Subject: Request for Comment on Cabramatta Rail Loop – extended exhibition period (SSI 9186)

EES has reviewed the response to submissions prepared by ARTC undated and provide the following comments:

THIS PAGE HAS BEEN LEFT INTENTIONALLY BLANK

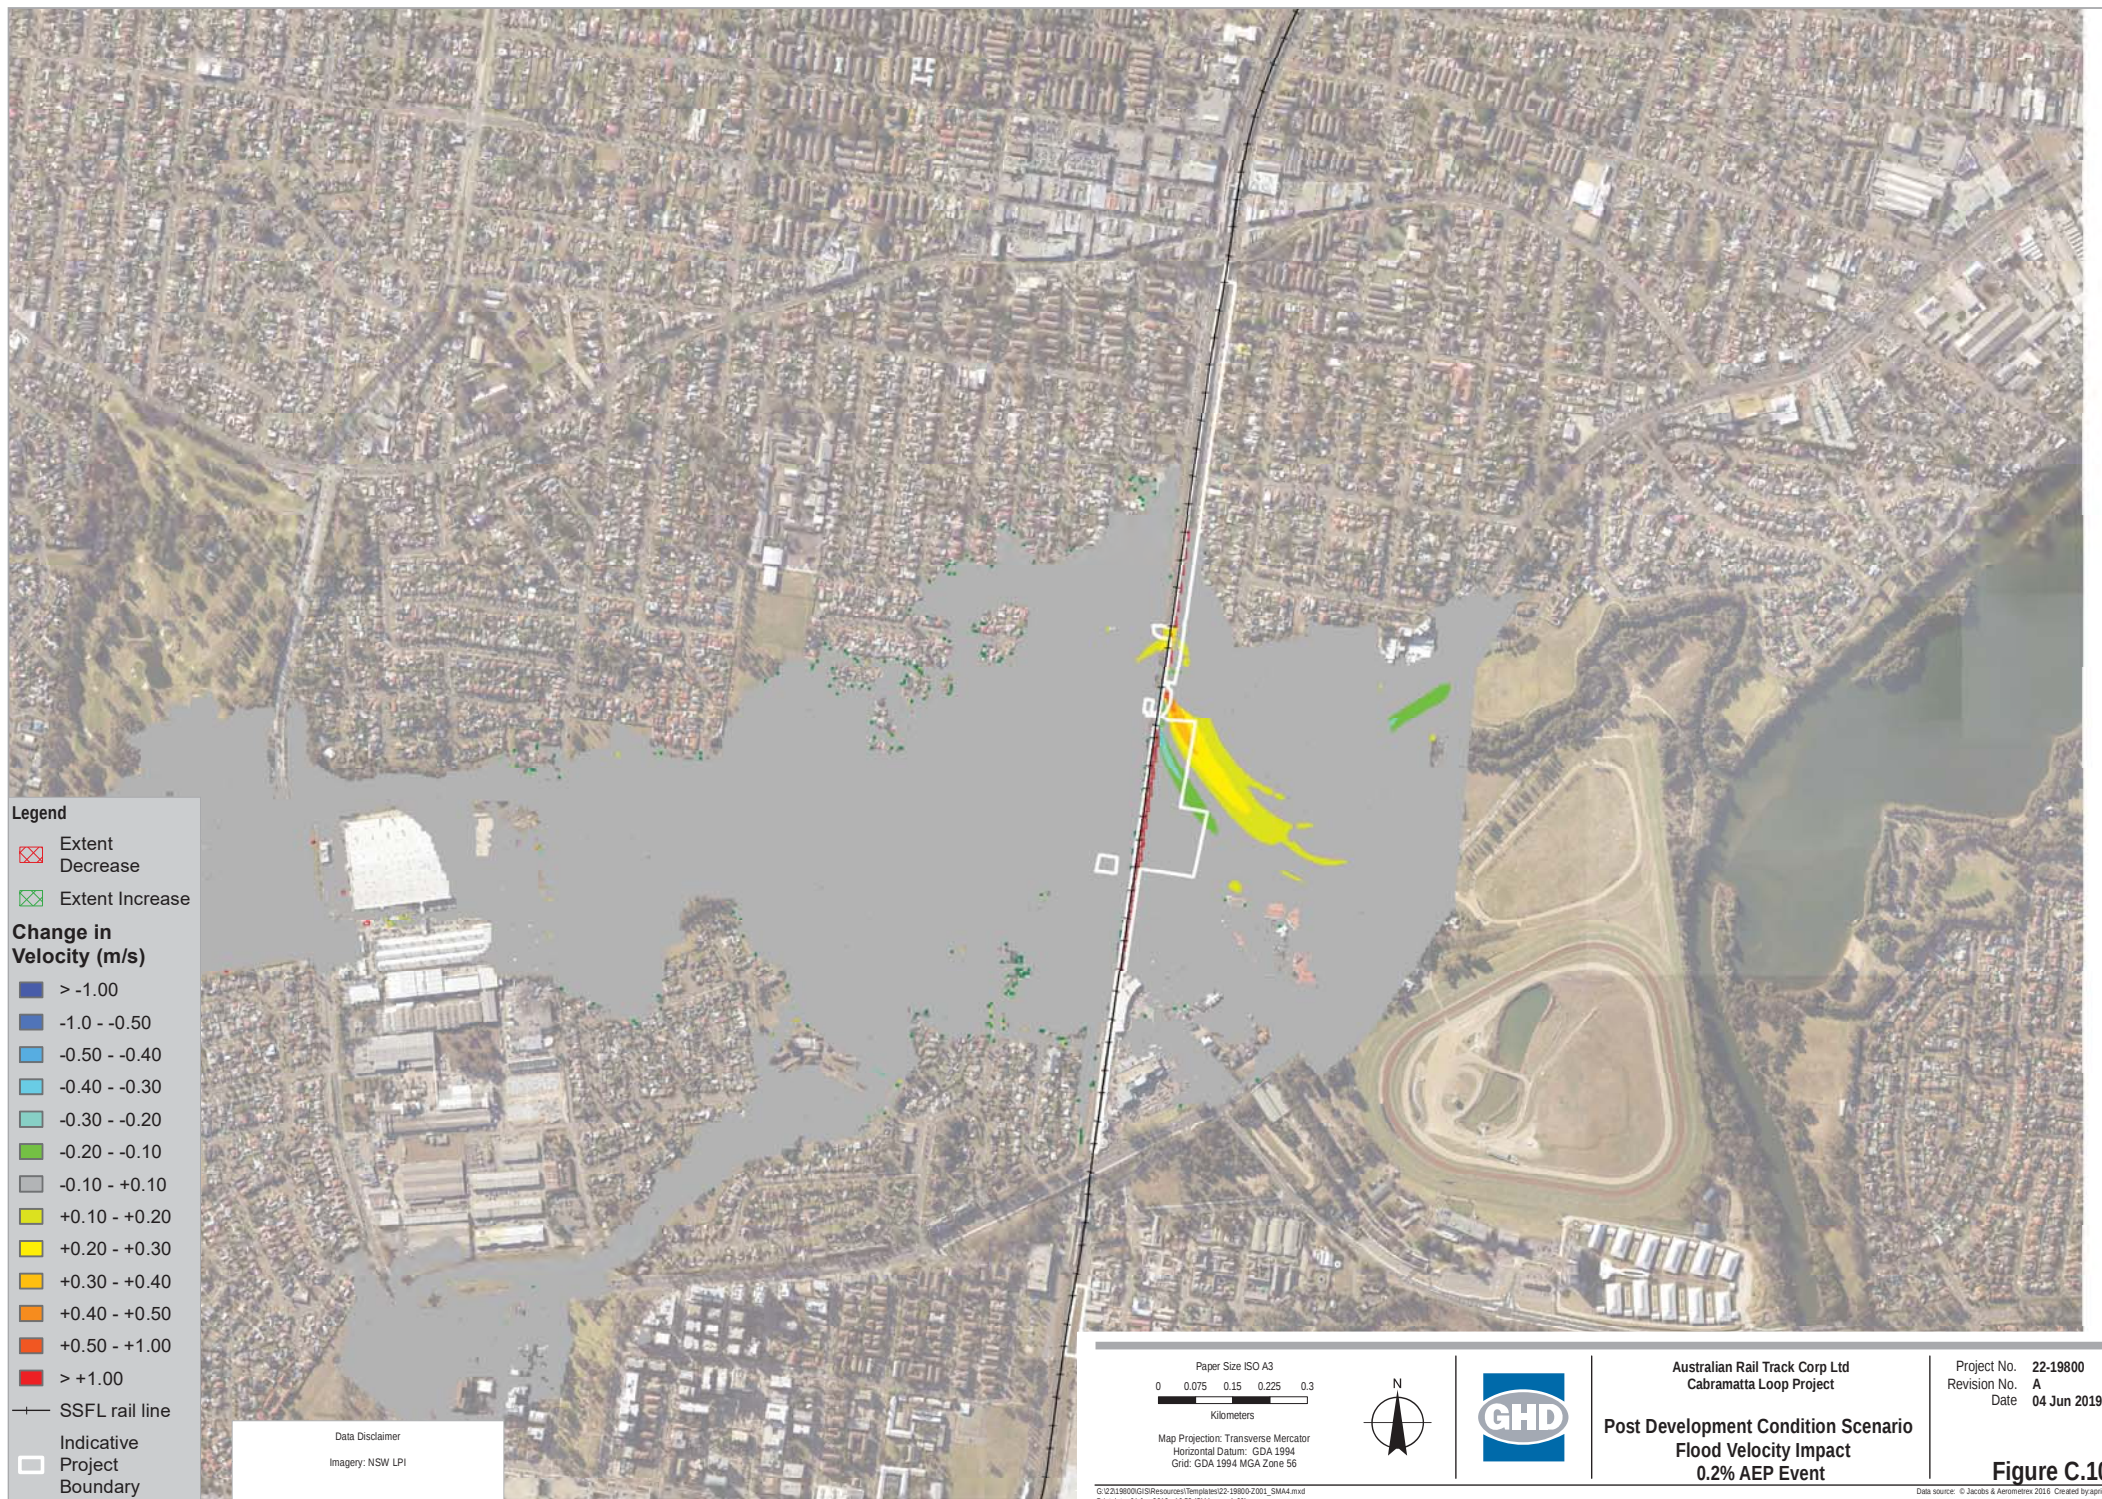
The flood maps should include the changes in flood depths within the Bloomfield Street Catchment with and without infrastructure development (i.e. difference of flood levels) for a range of events to evaluate flooding impacts and the development of appropriate mitigation measures.
